# KITTITAS COUNTY

## DEPARTMENT OF PUBLIC WORKS

**TO:** All Staff  
**FROM:** Public Works Plan Review Team  
**DATE:** January 17th, 2024  
**SUBJECT:** CU-23-00006 Honest Cut Meats LLC

EXISTING CONDITIONS (DETAIL)

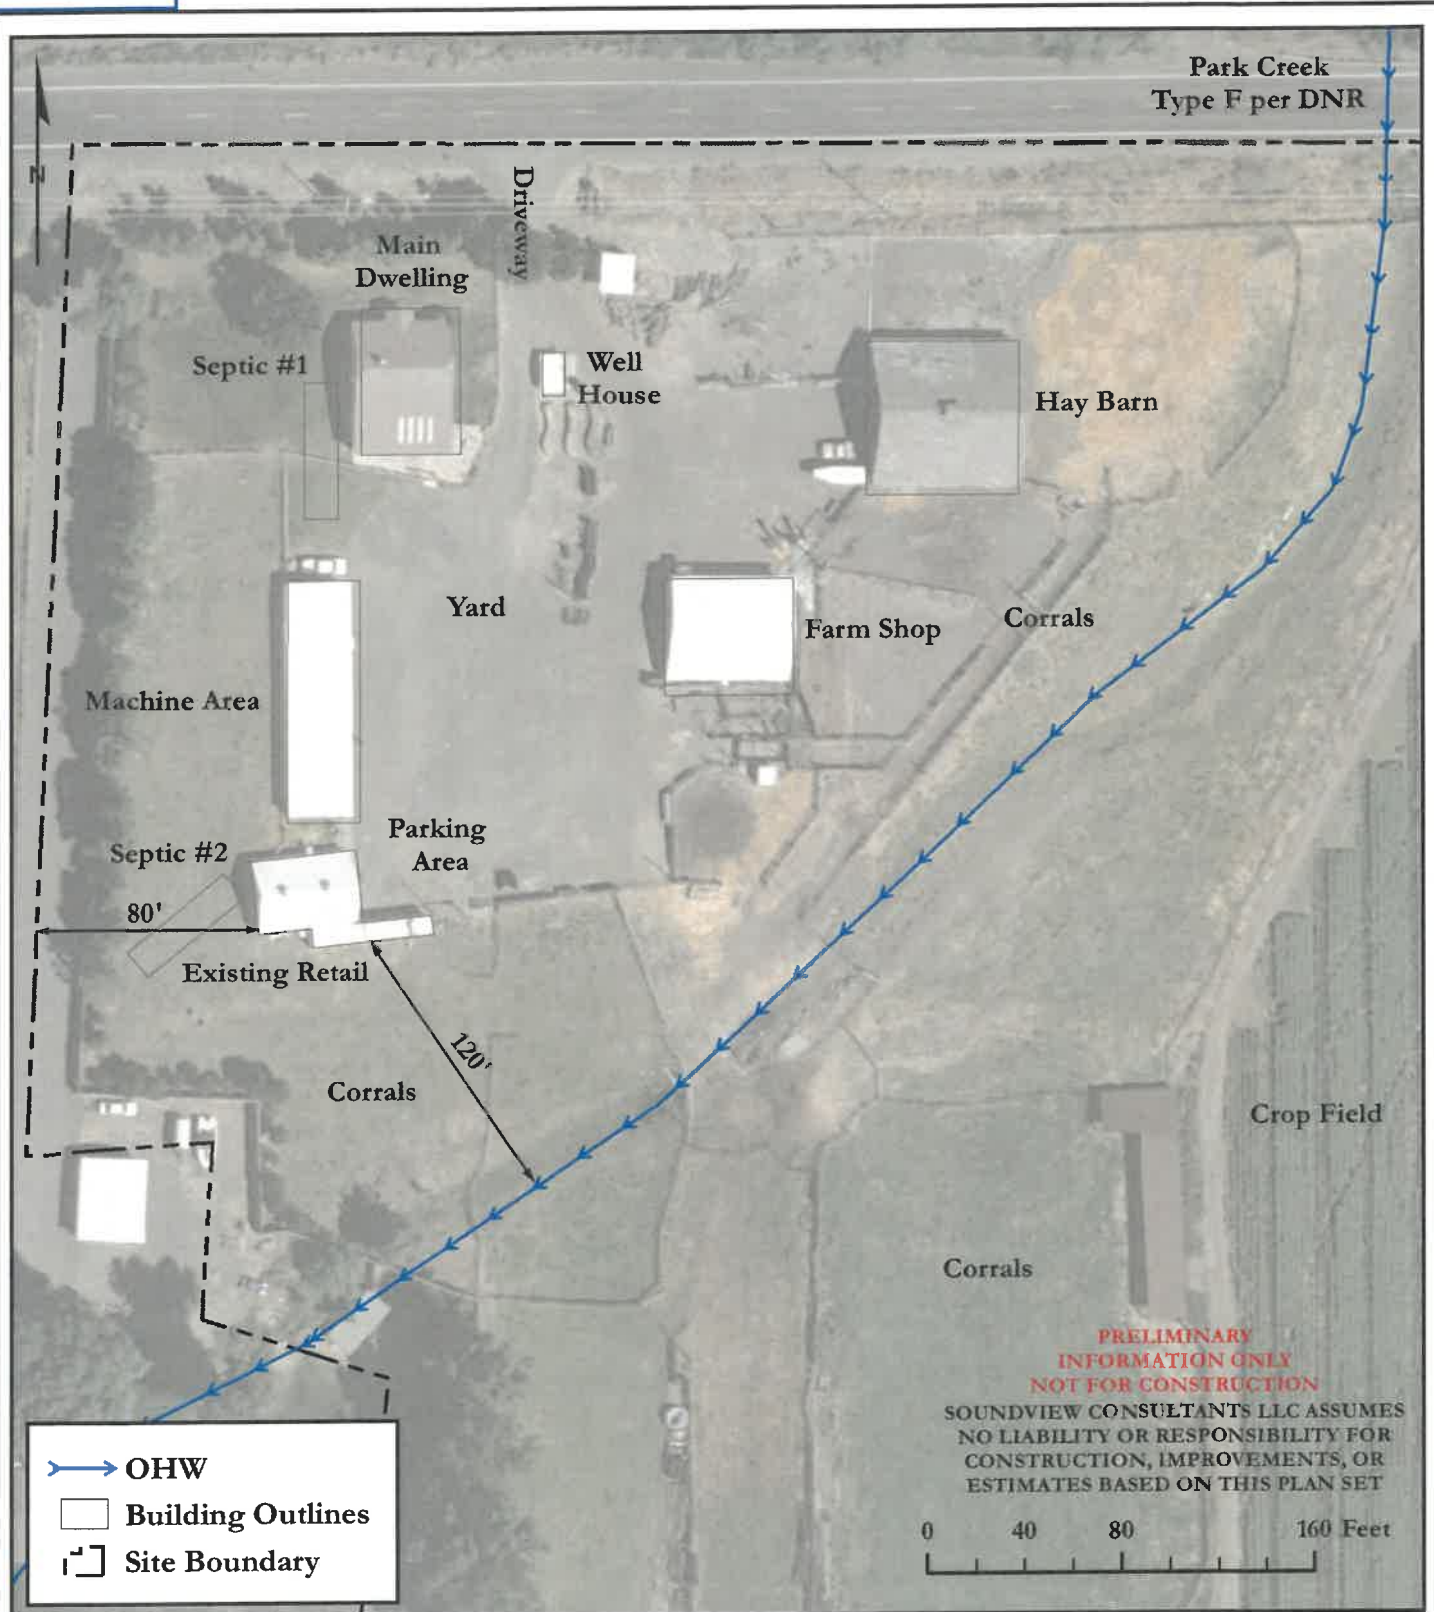
| <b>ACCESS</b>                     | No access requirements, site plan shows existing access to be used. (JS)   |
